Arun District Planning Department

Further to the response posted by Mr and Mrs Malcolm Jenkins on 22/1/19 regarding objections to planning application FG/220/18/PL.

Drawing Title: PROPOSED SITE PLAN

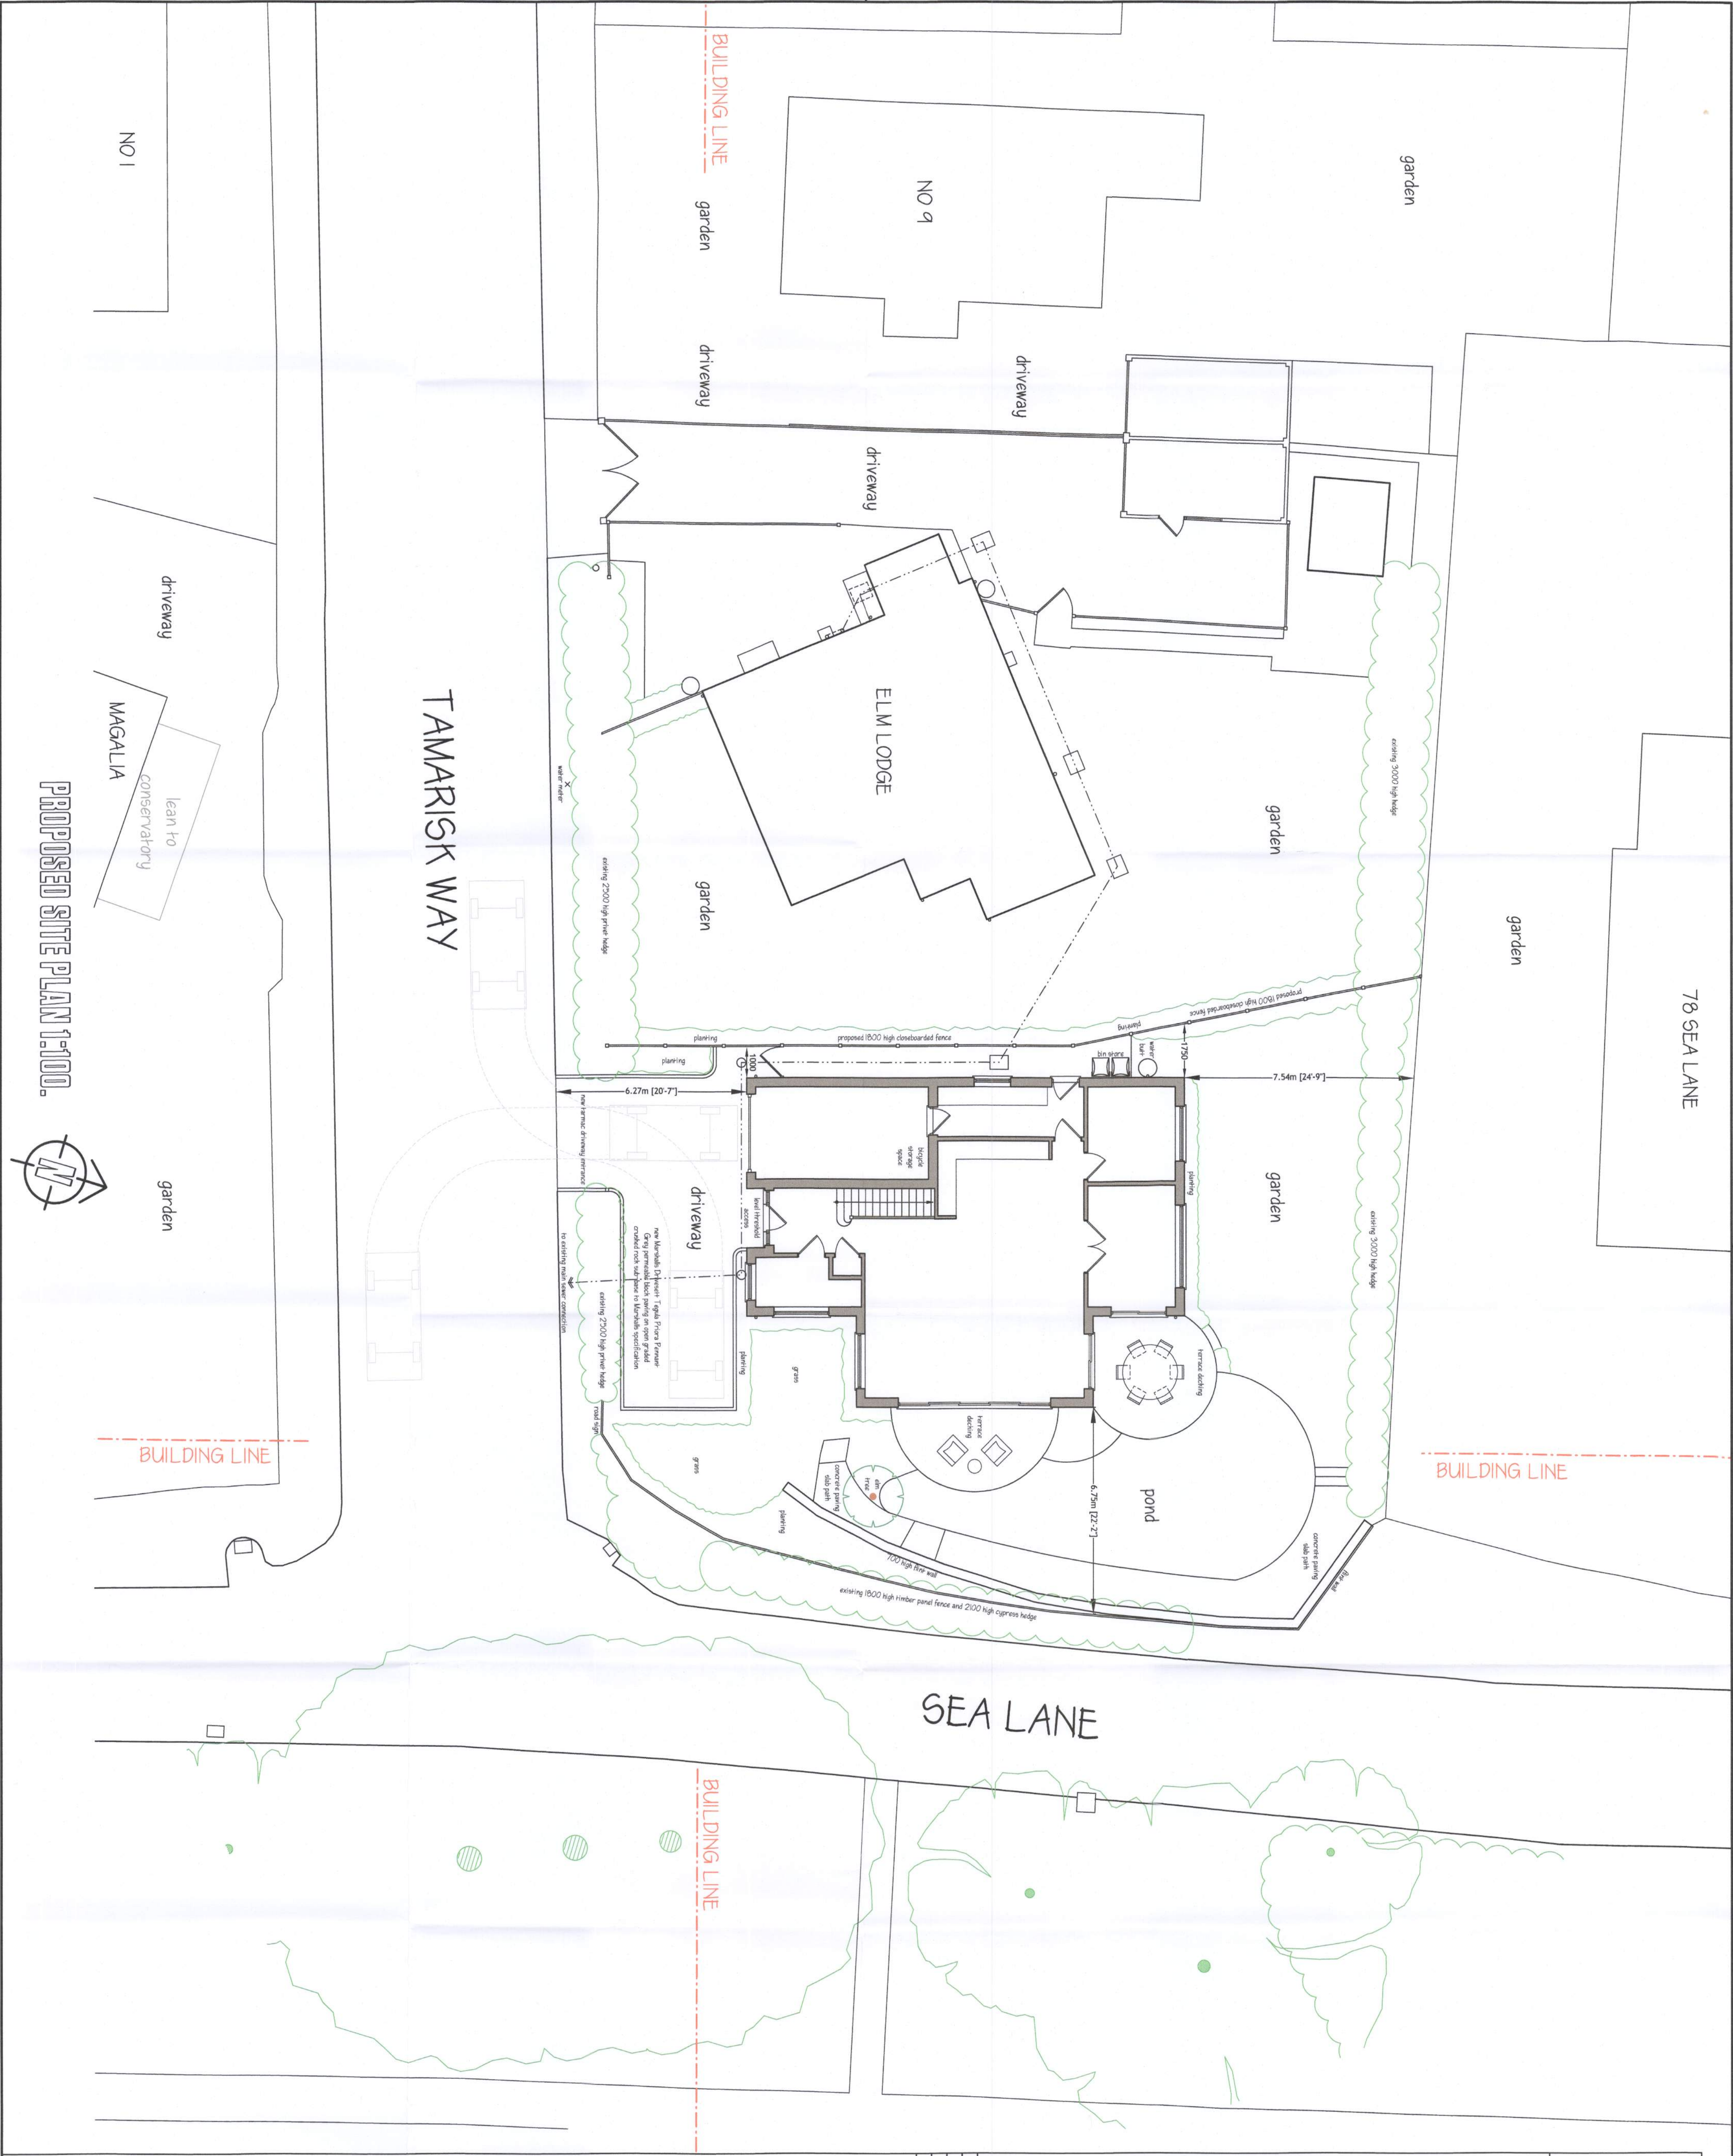
Whilst there obviously is currently no evidence of the junction of Tamarisk Way with Sea Lane operating unsafely, this does not mean that the additional driveway, so close to the entrance does not constitute a hazard. How can this be confirmed without a site visit from WSCC?

We would point out that whilst the same amount of rainfall would be present, currently much of this is absorbed by the grass and vegetation in the garden site. If this area is covered by a house and hardstanding, the runoff clearly has to go somewhere else i.e. the pond and drainage areas.

PROPOSED ROOF PLAN AND
PROPOSED ELEVATIONS

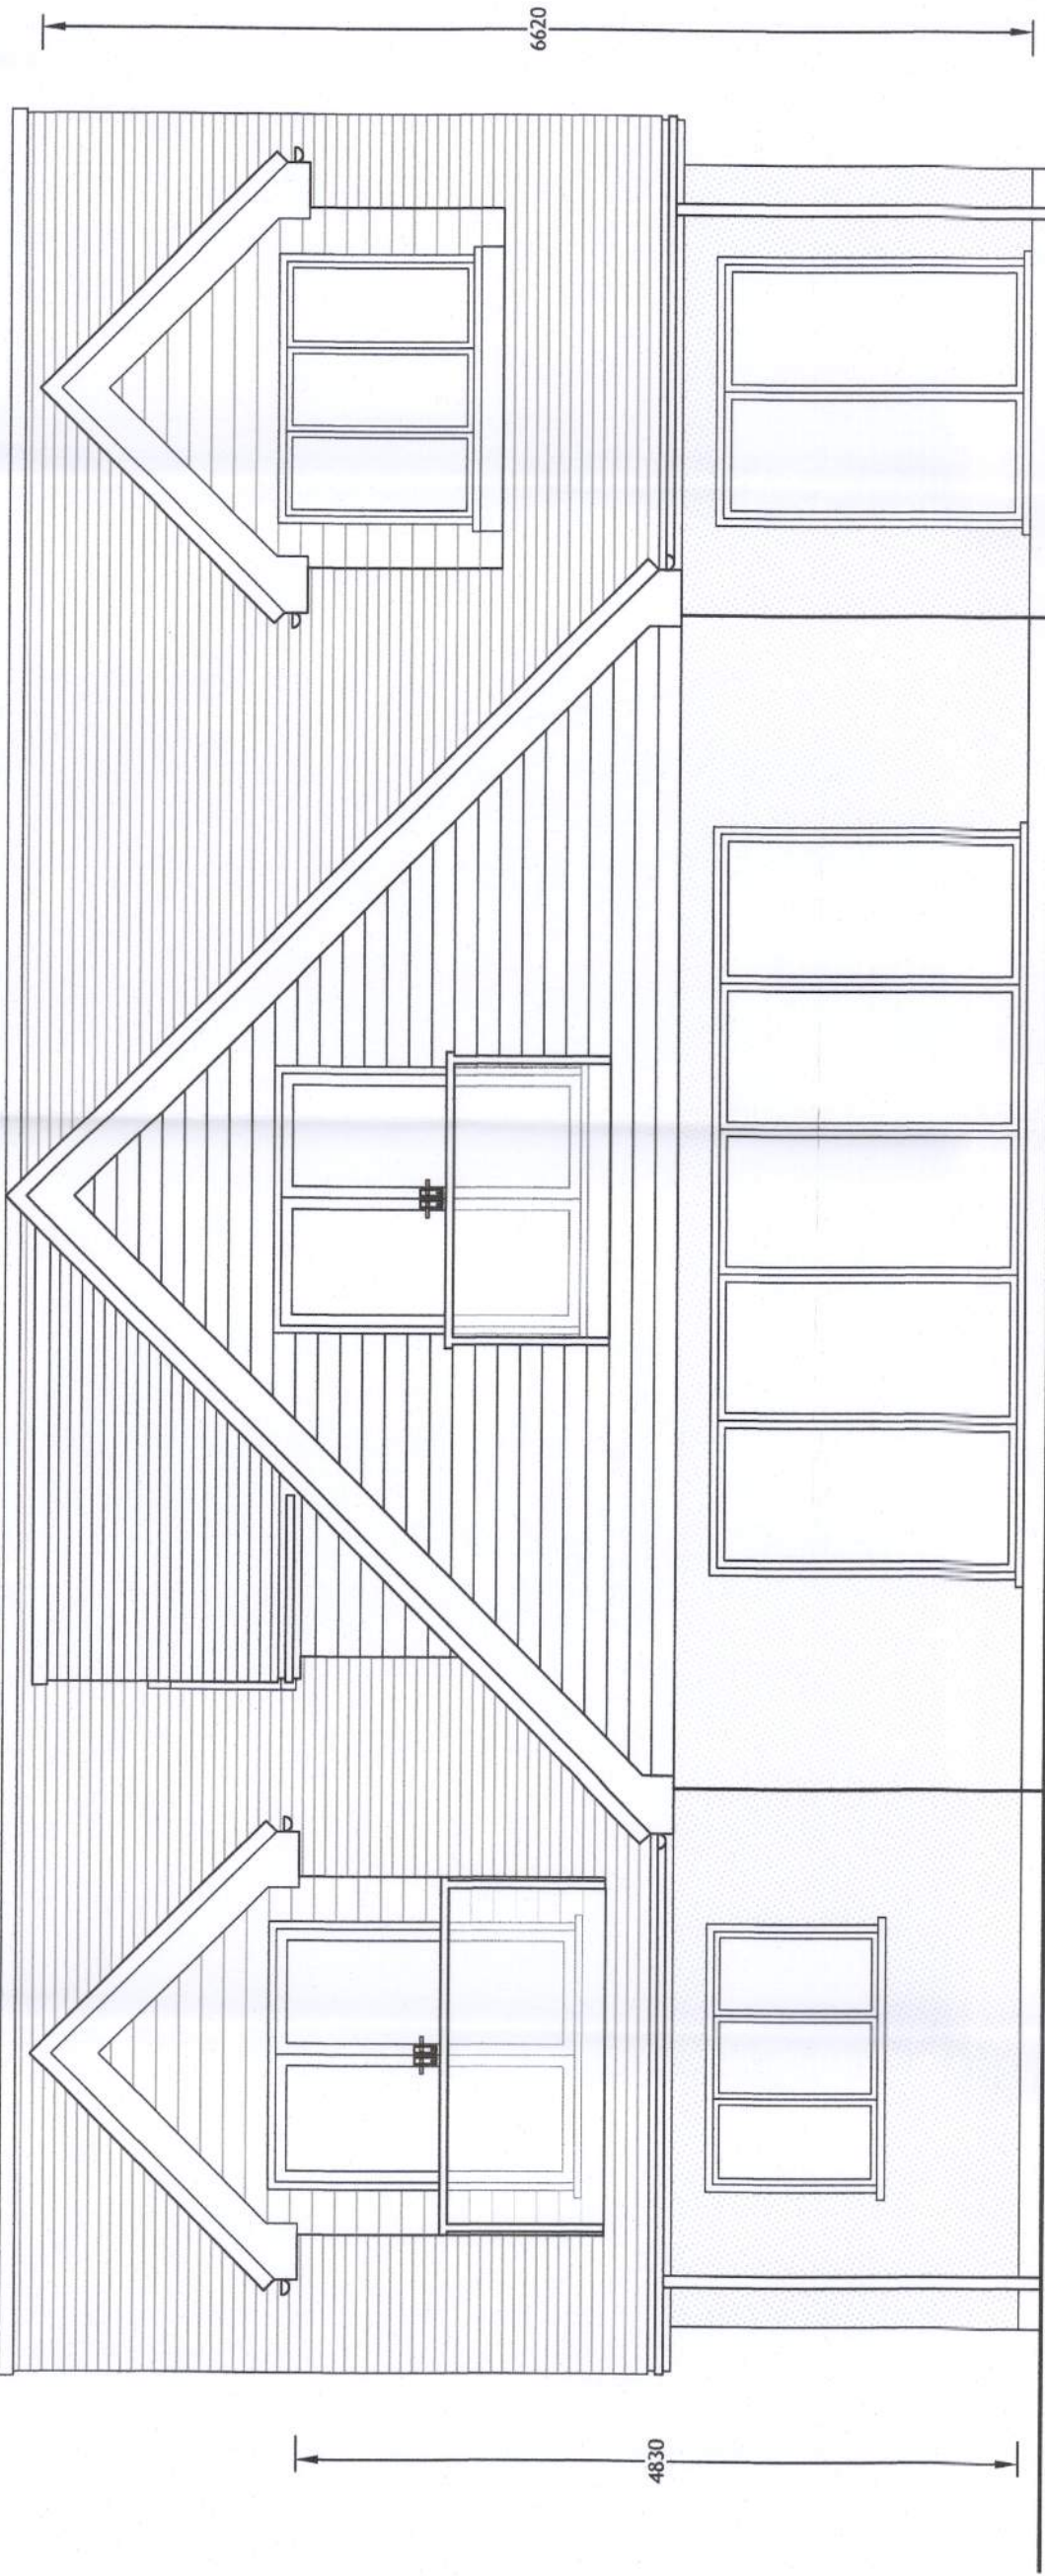
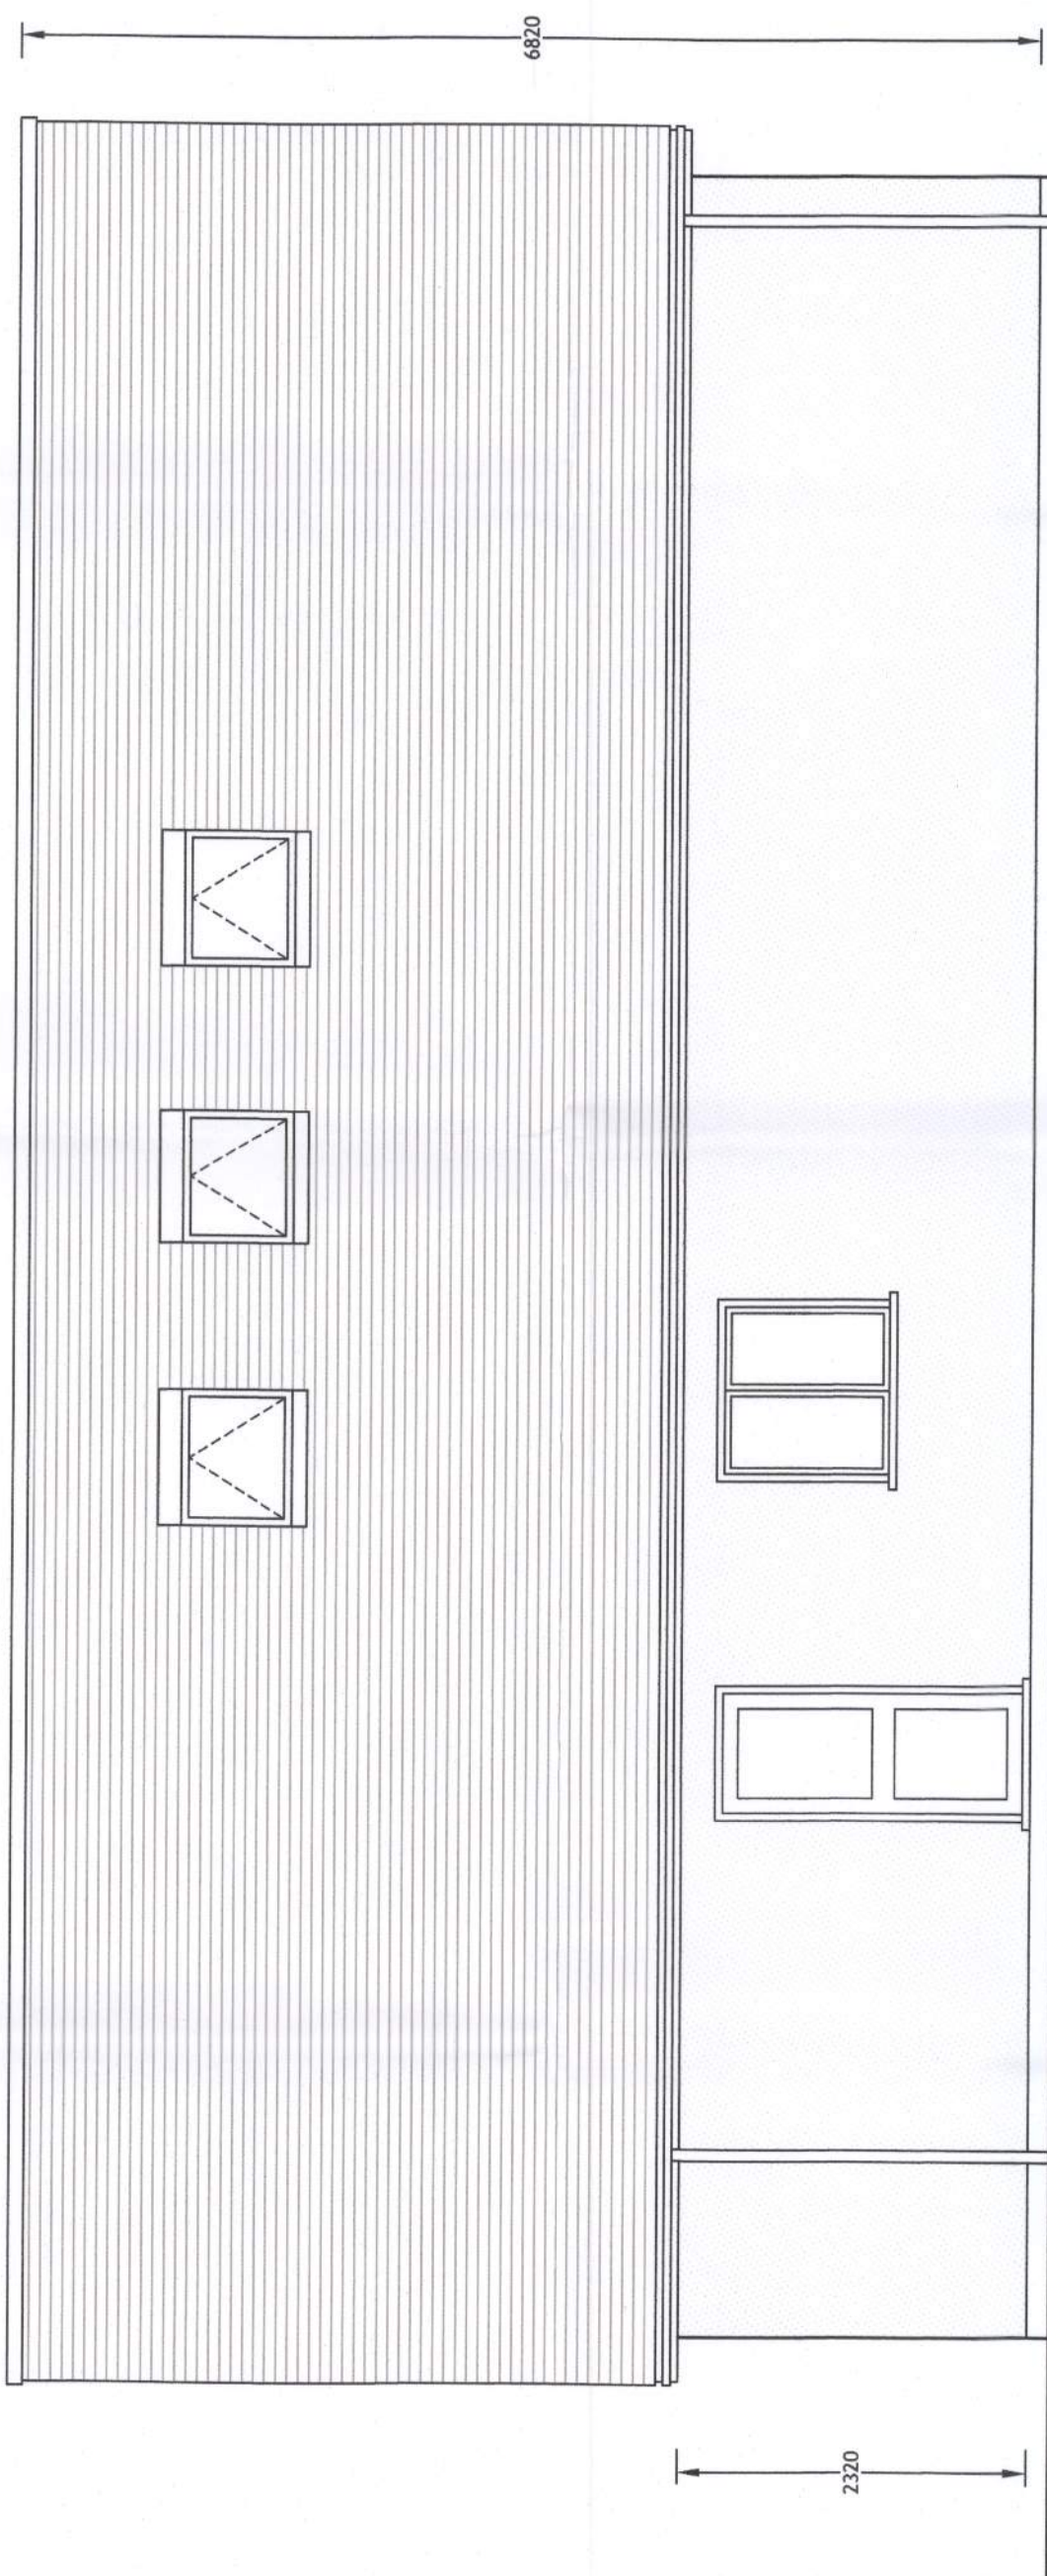
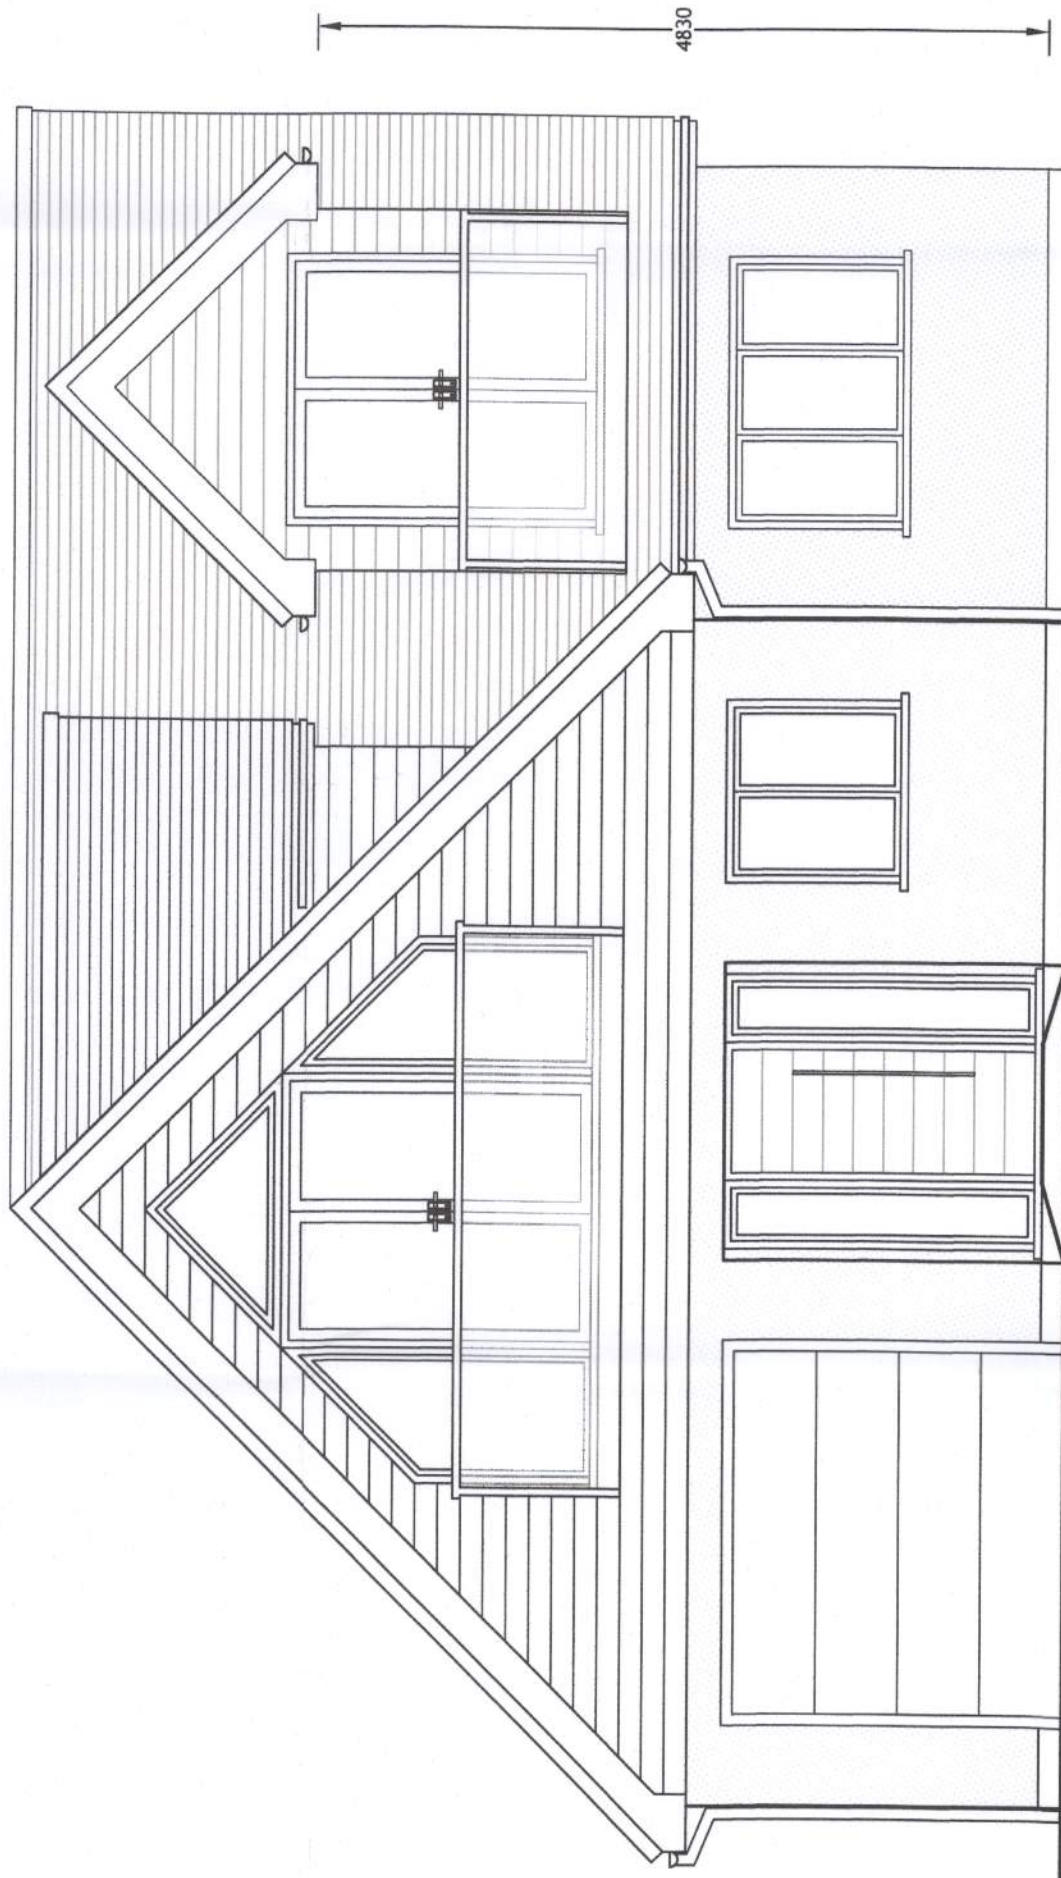
The consequence of the design of the new house and the changes to Elm Lodge means that 4 full length Juliette Balcony windows would directly face and intrusively overlook our house and garden, comprehensively affecting our privacy. We note that these windows will have 'mirror foil' to ensure the privacy of the occupants. Do we not have the same rights?
